# COUNTY COUNCIL'S RESPONSE TO CONSULTATION ON THE FOLLOWING DEVELOPMENT PROPOSAL

**Application No:** 20/00293/OUT

**Proposal:** Outline application (Phase 1B) including access (all other matters reserved) for approximately 4,413 sqm B1 office space (47,502 sqft) GIA, approximately 273 residential units (Use Class C3) including ancillary gym, approximately 177 sqm GIA of café space (Use Class A3), with an ancillary, mixed use co-working hub (794 sqm/ 8,550 sqft GIA), multi-storey car park, multi-use games area (MUGA), amenity space, associated infrastructure, parking and marketing boards

**Location:** Bicester Gateway Business Park, Wendlebury Road, Chesterton

Appendix B – Tracking Drawing

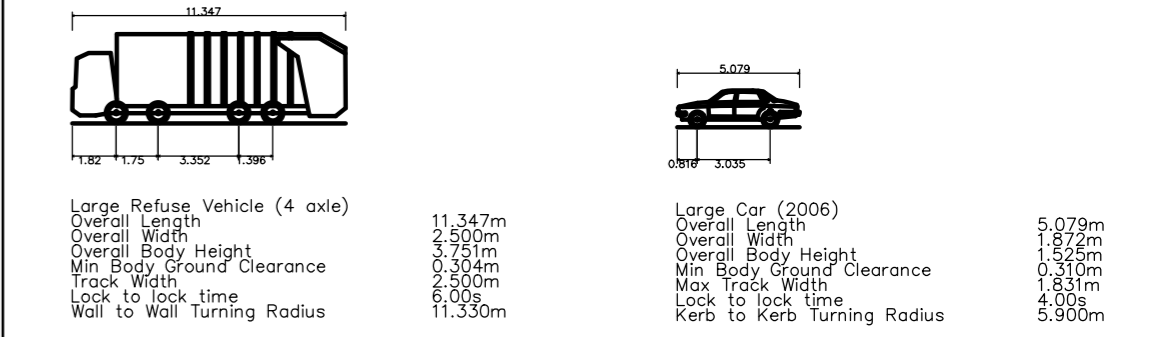
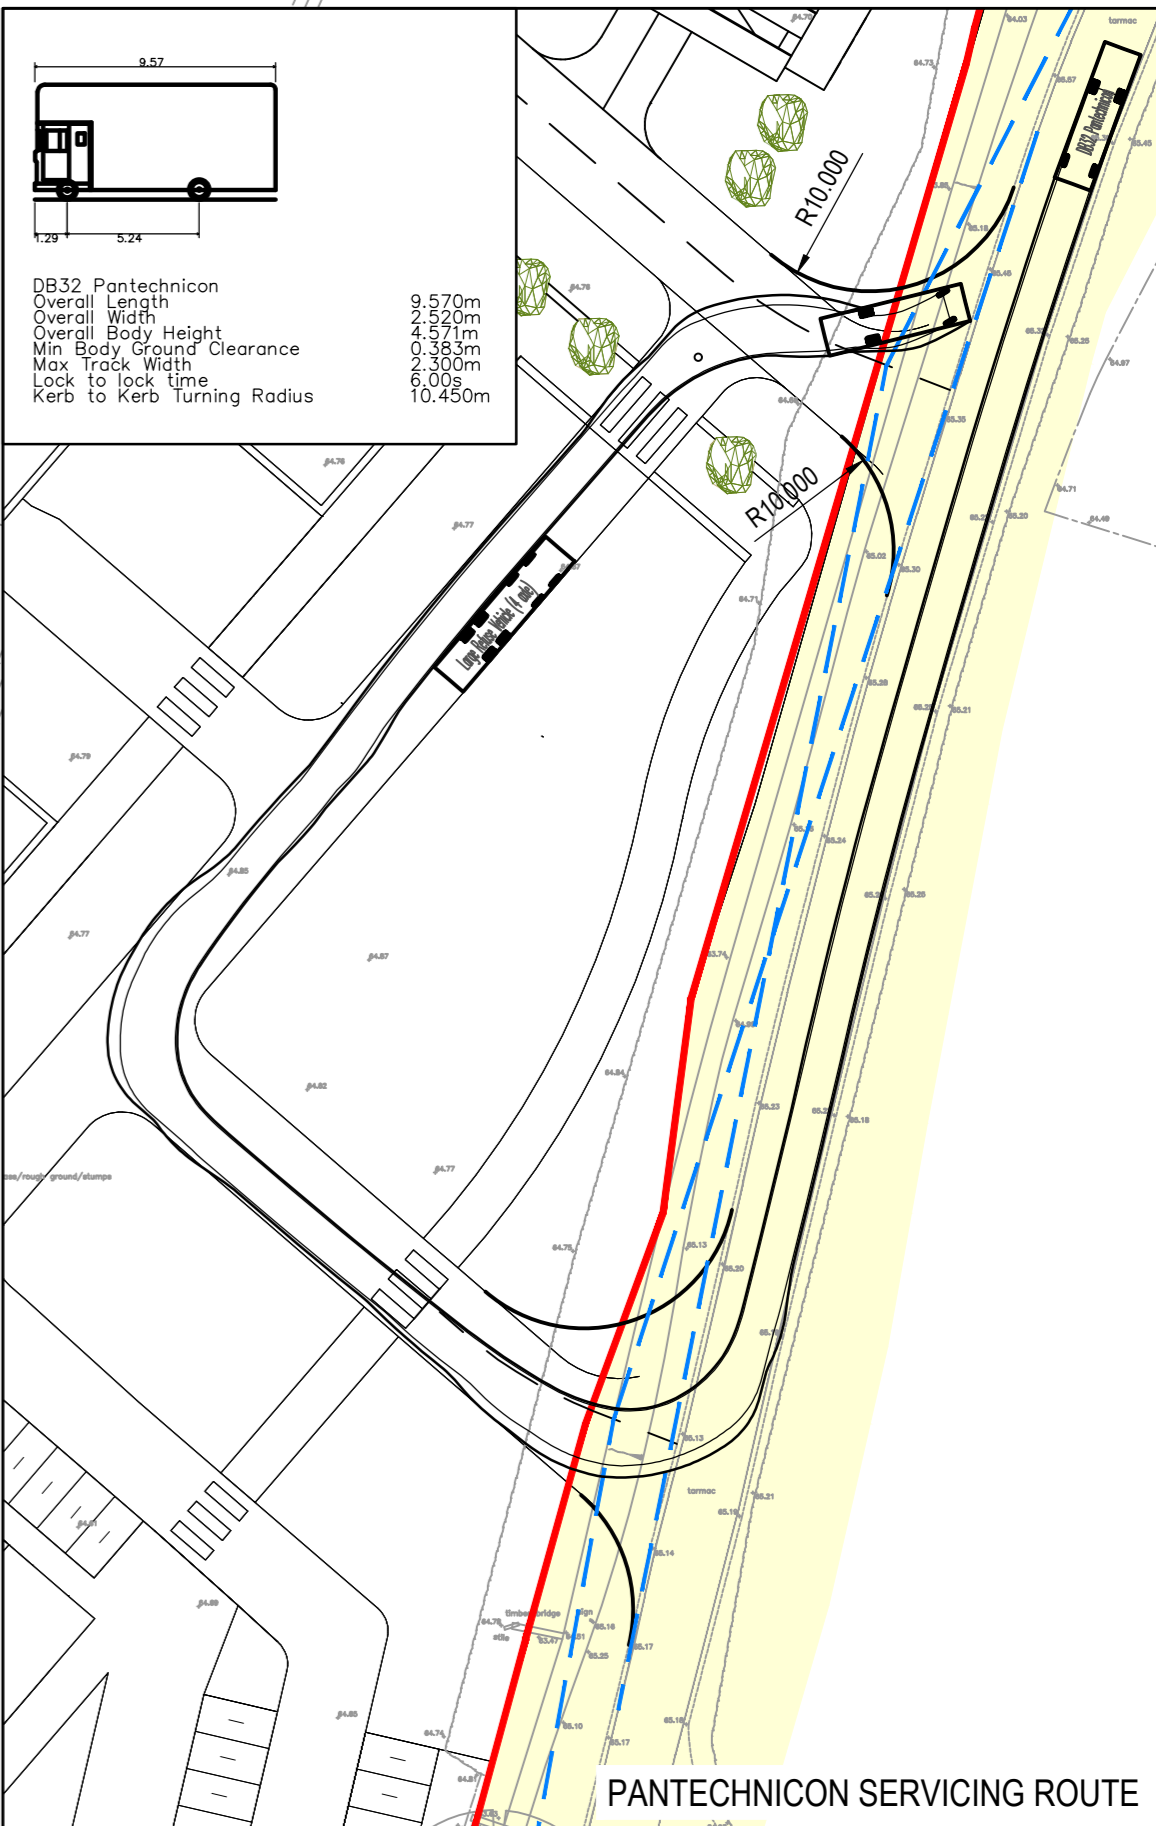
No vehicle tracking has been presented to demonstrate that suitability for appropriate vehicle use. I would expect that access being a detail at this stage should be tracked for refuse and delivery service vehicles. **(reason for objection)**

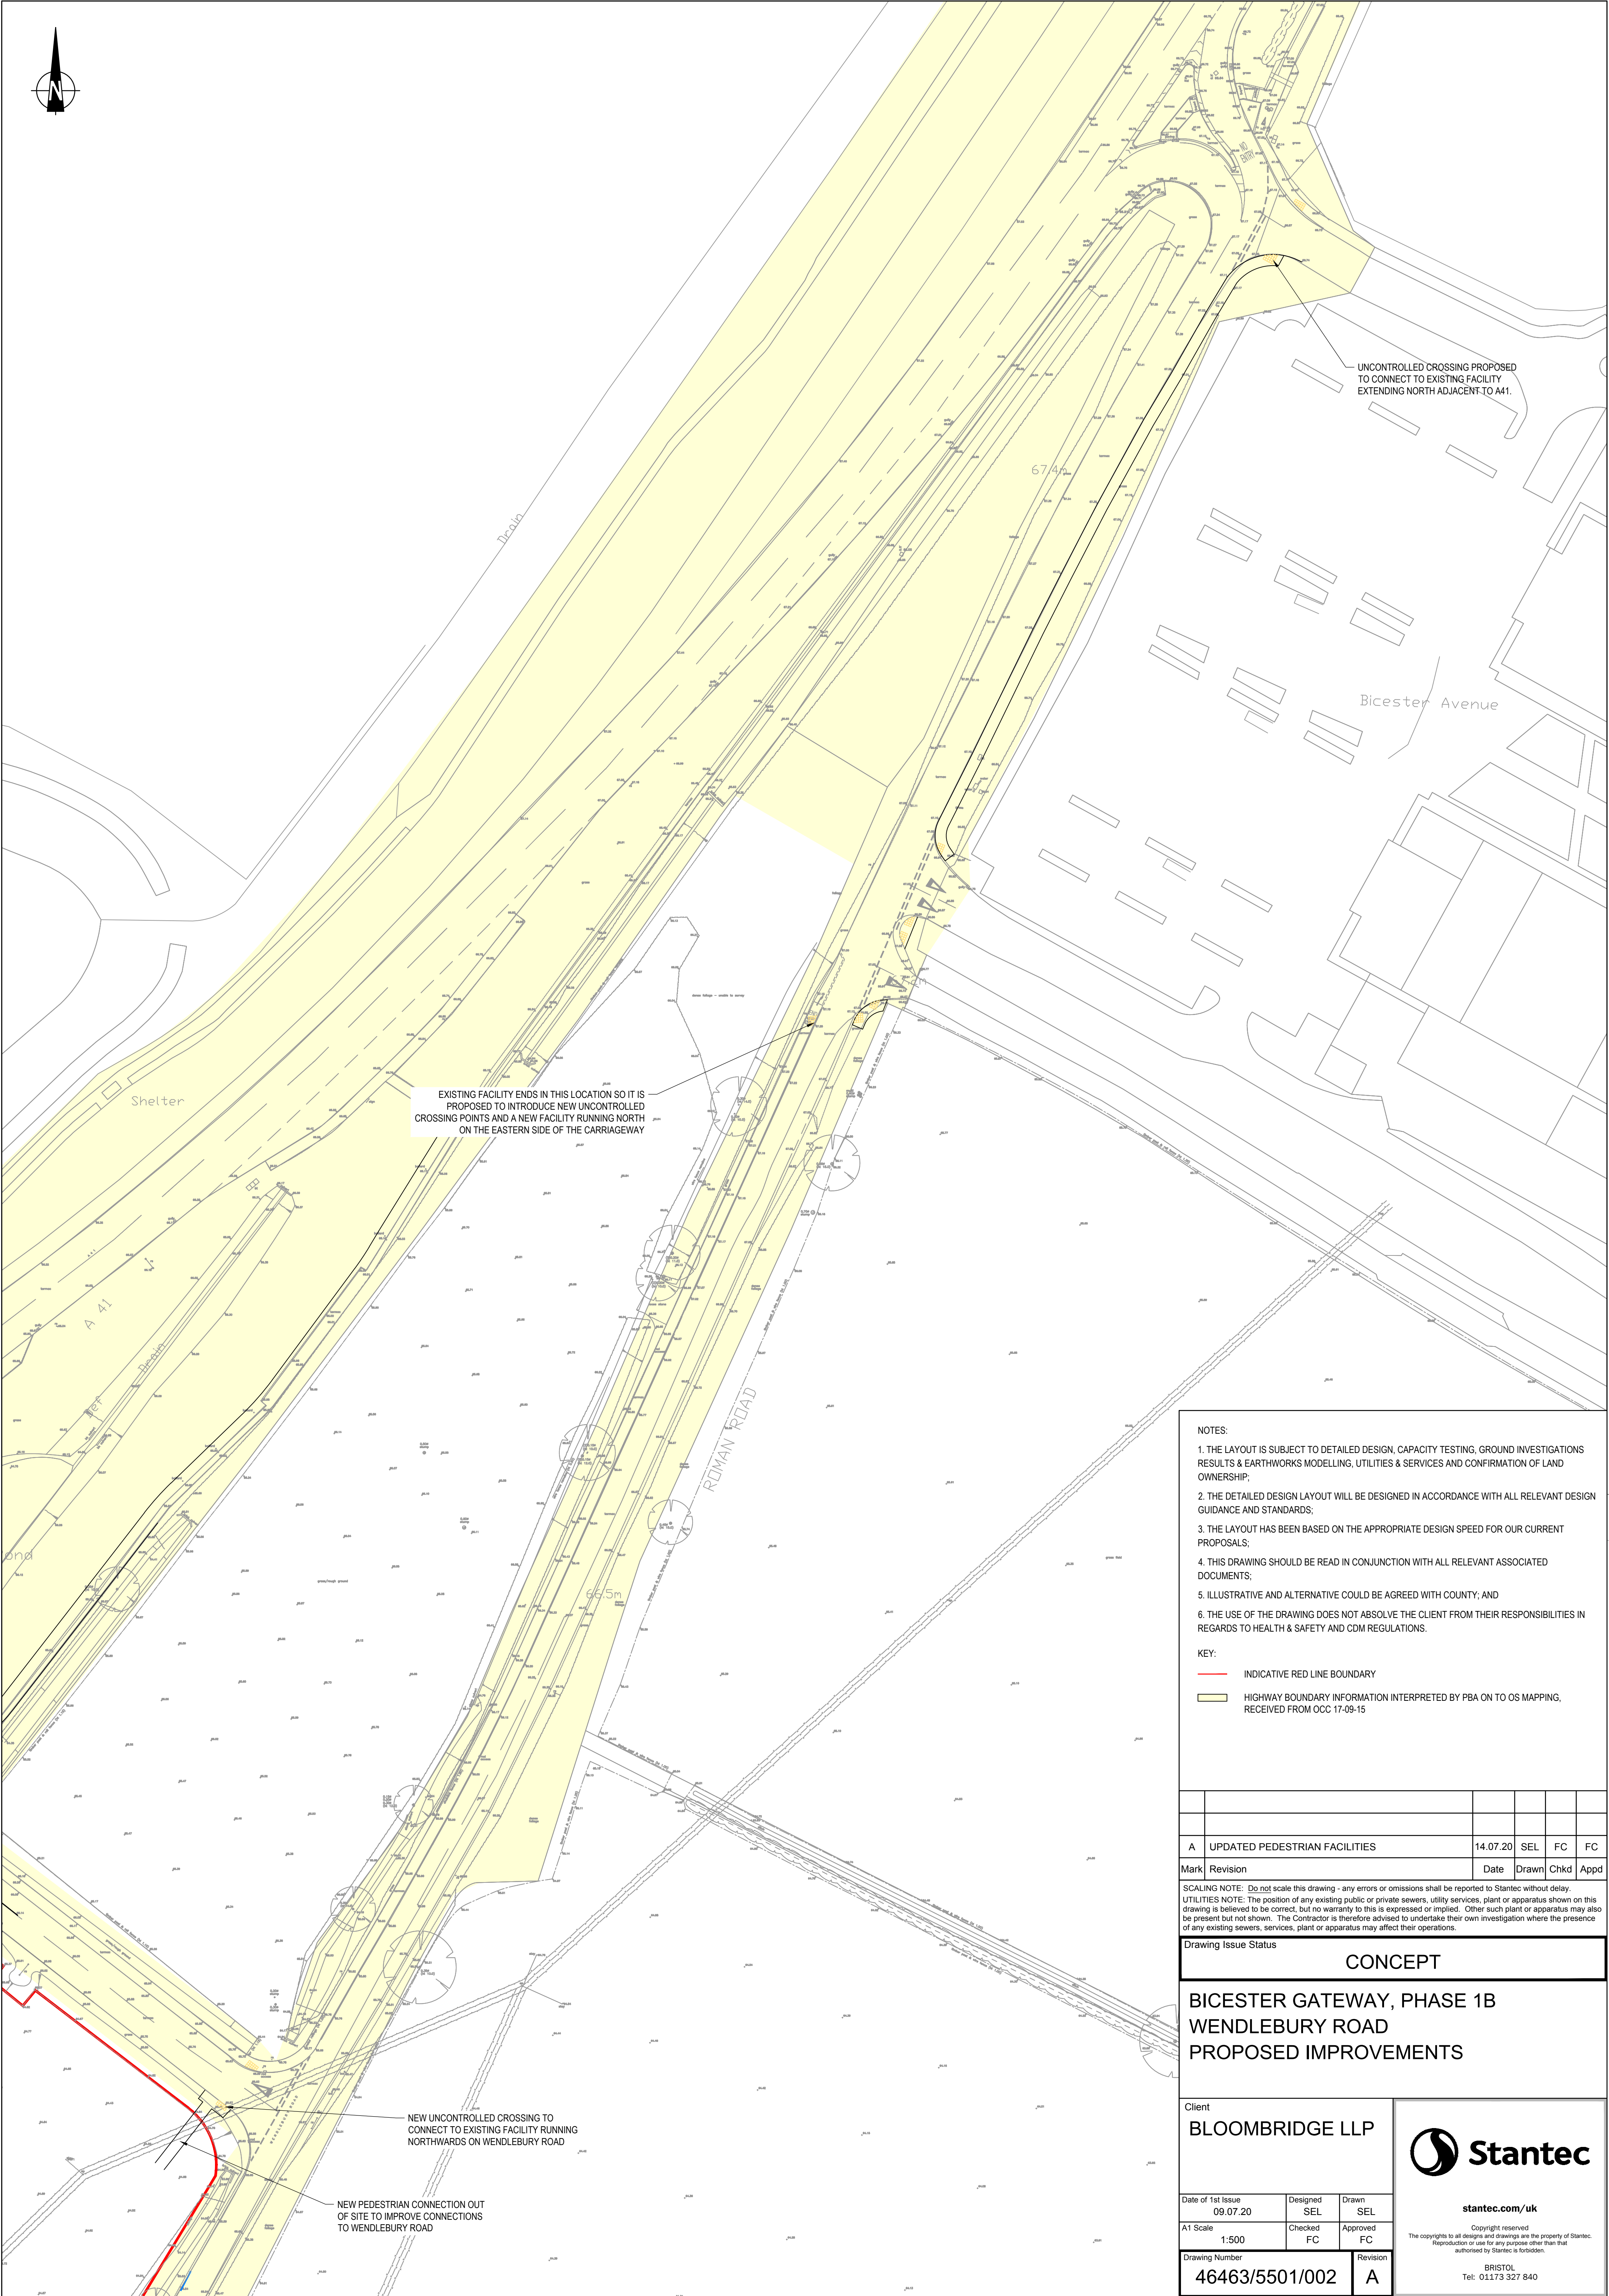
Drawing Ref: 46463/5501/001 within the TA shows the site access arrangements with visibility splays of up to 90m on the southern site access. Whilst the right-hand visibility from the southern site access is adequate for speeds within a 40mph zone, I feel the position of the proposed speed zone change should be extended further south to ensure that approaching vehicles are within the required 40mph.

Also, in consideration of the site frontage being along a Sustrans Cycle Route, the site access arrangements need to show provision of a shared use cycle track/footway on the development side of Wendlebury Road that tie into the committed/existing facilities. A solution is required that does not cause undue inconvenience for the users of the existing cycle route or expose residents and visitors that may choose to access the site from this frontage to unacceptable road safety risk. It is also necessary to cater for likely movements between the development and the employment that would emerge at the back of Bicester 10 Ph2 allocated. Pedestrians would not take the detour to walk via the A41 and back via Vendee Drive. Equally, it would be considered unsafe to expect pedestrians to walk in the carriageway of Wendlebury Road.

The access plan also proposes a pedestrian and cycle bridge at the north western corner to link the site to the existing pedestrian/cycle facility on the A41. This bridge lies within highway land. Because of this, its detail is required to meet DMRB standards. While OCC would not object to the bridge being provided,
